From: Martyn White
Sent: 13 December 2018 16:04
To: Planning.Responses
Cc: Zac Denton
Subject: R/259/18/HH

R/259/18/HH

The application is for works to the roof of the property to provide: 2 No. dormer windows to the north elevation, 2 No. rooflights to south elevation, 1 No. rooflight to east elevation & 1 No. rooflight to west elevation

PROPOSED FRONT ELEVATION (North)

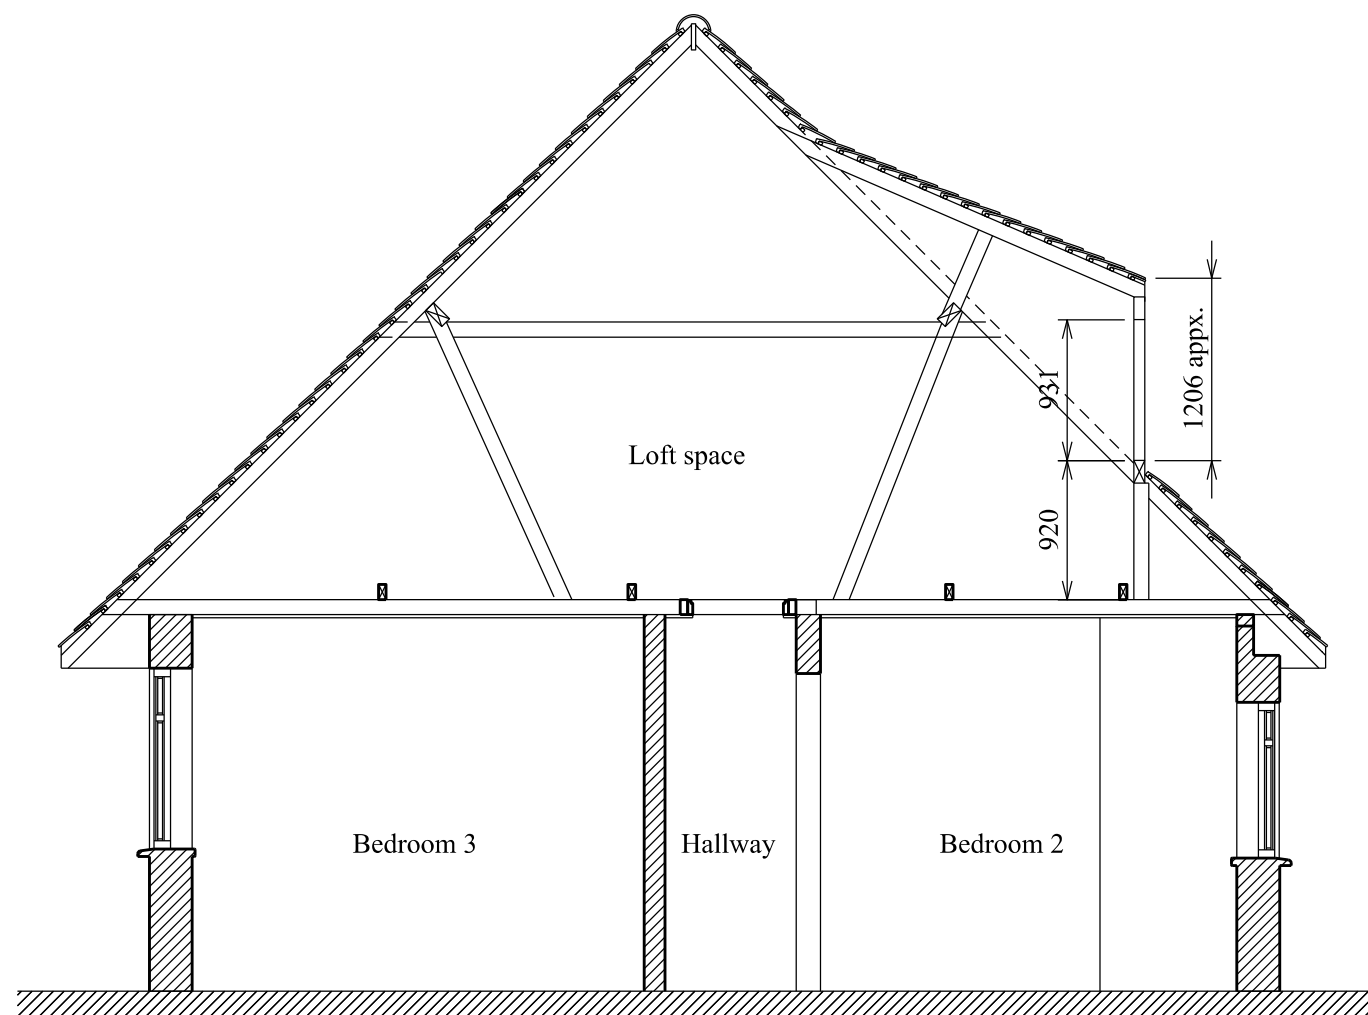
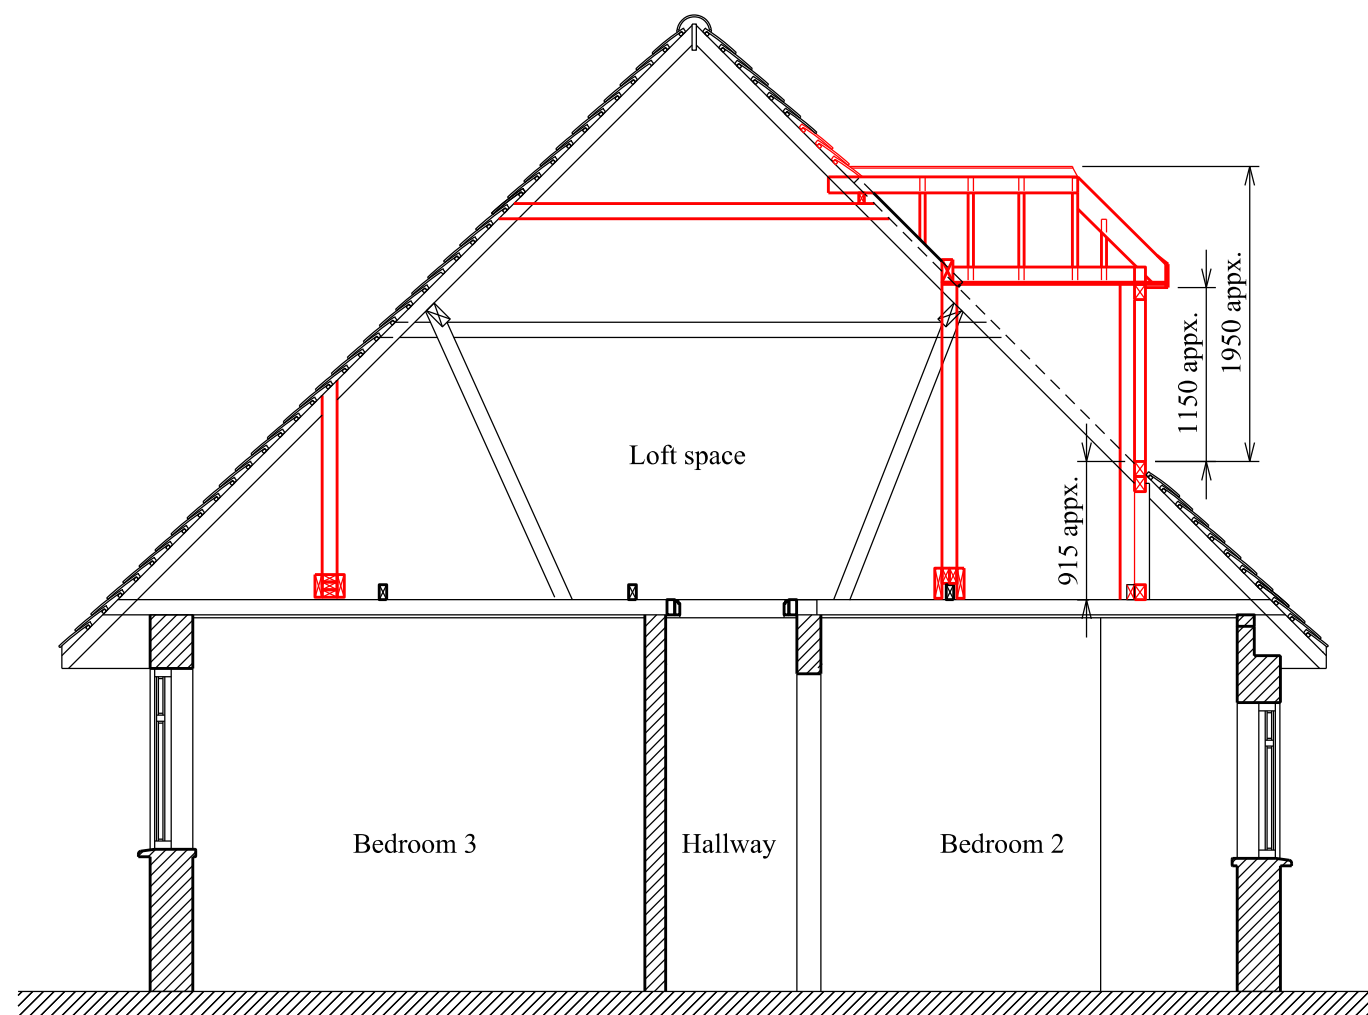
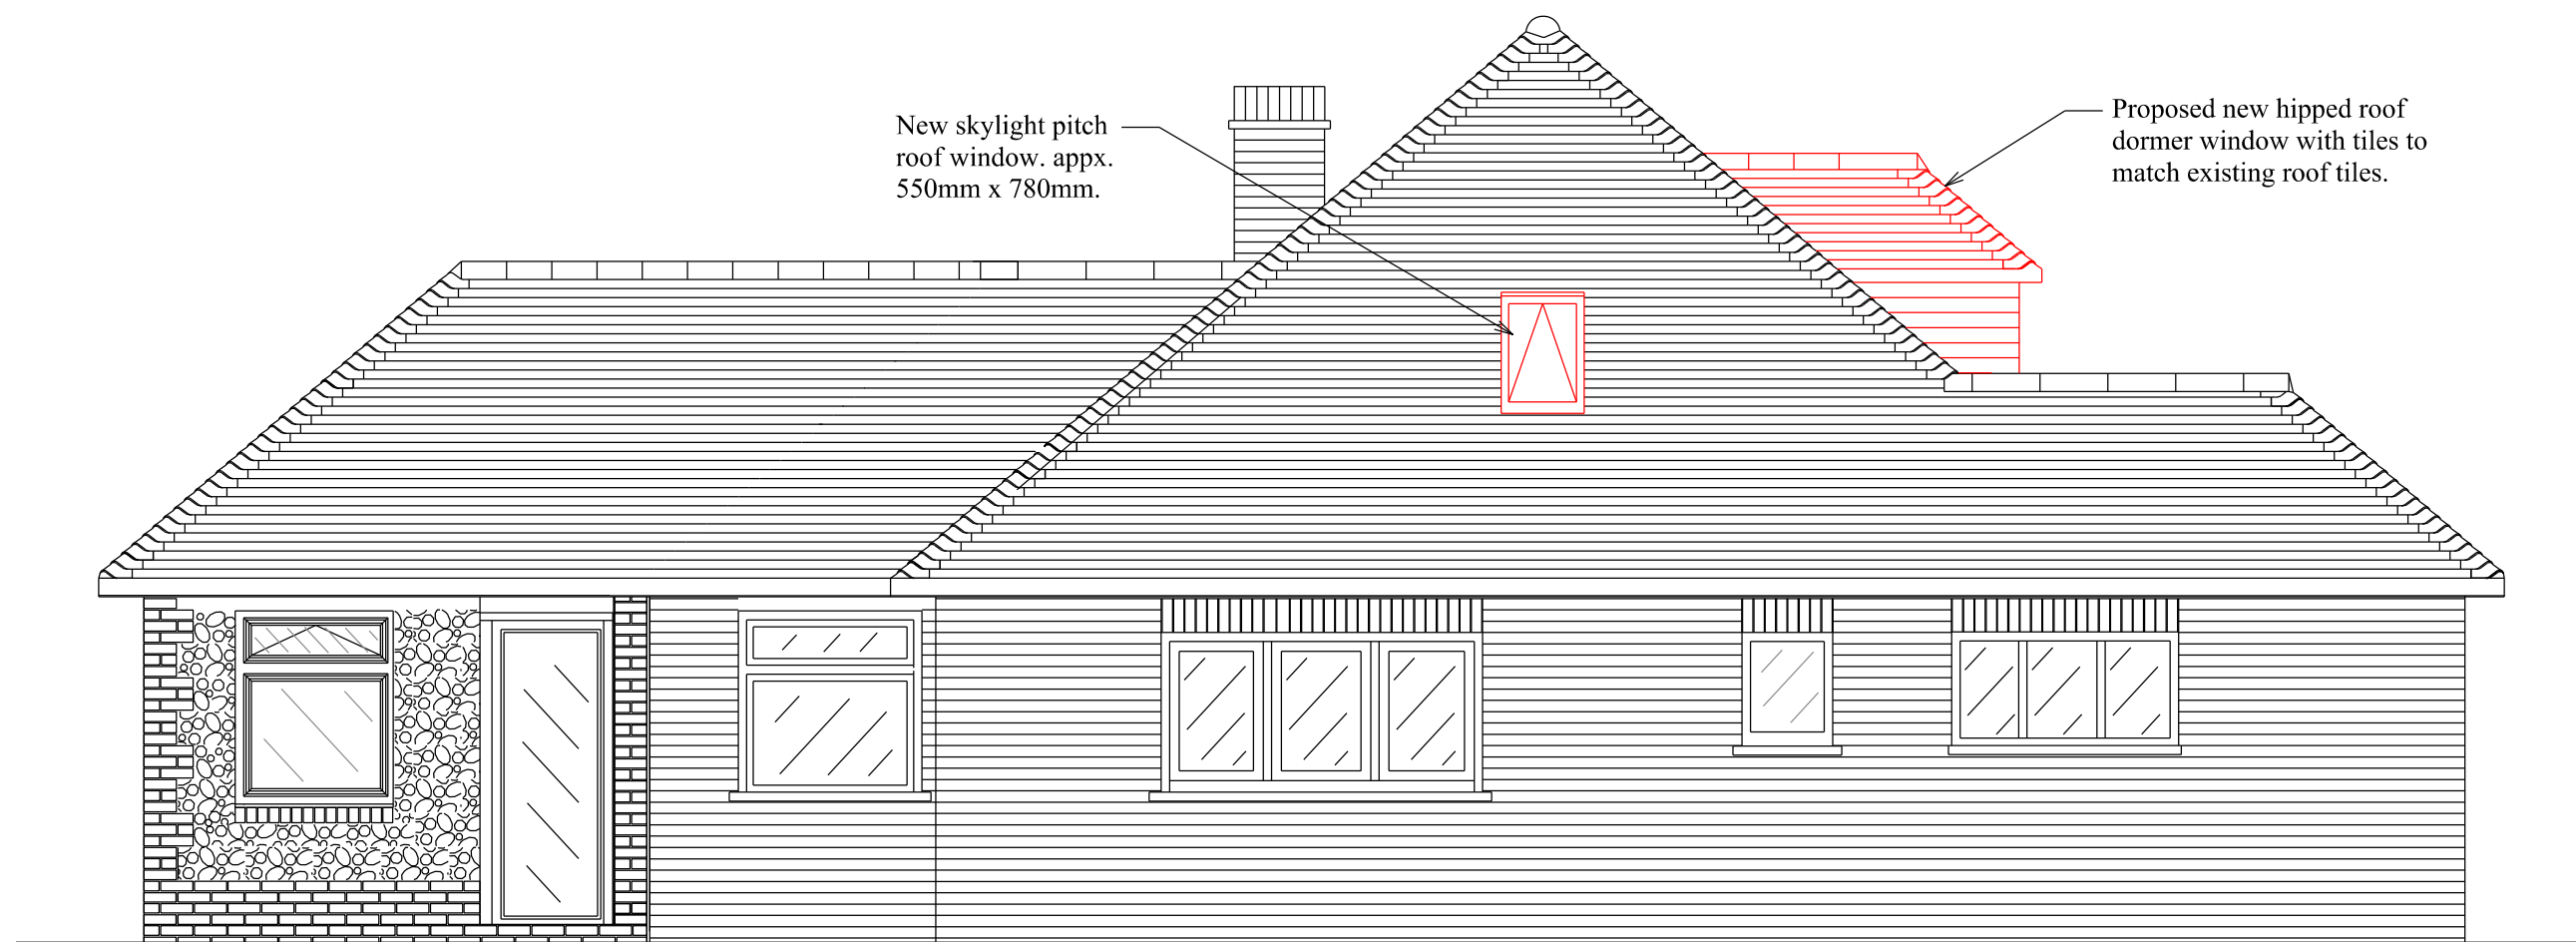
The application site is located close to a listed building. However, scale of the works on the front elevation mean that the proposed dormer windows will not affect the setting of the asset. As a consequence, it is considered that the proposed works will have a neutral impact on the listed building. Materials should reflect those existing on the property.
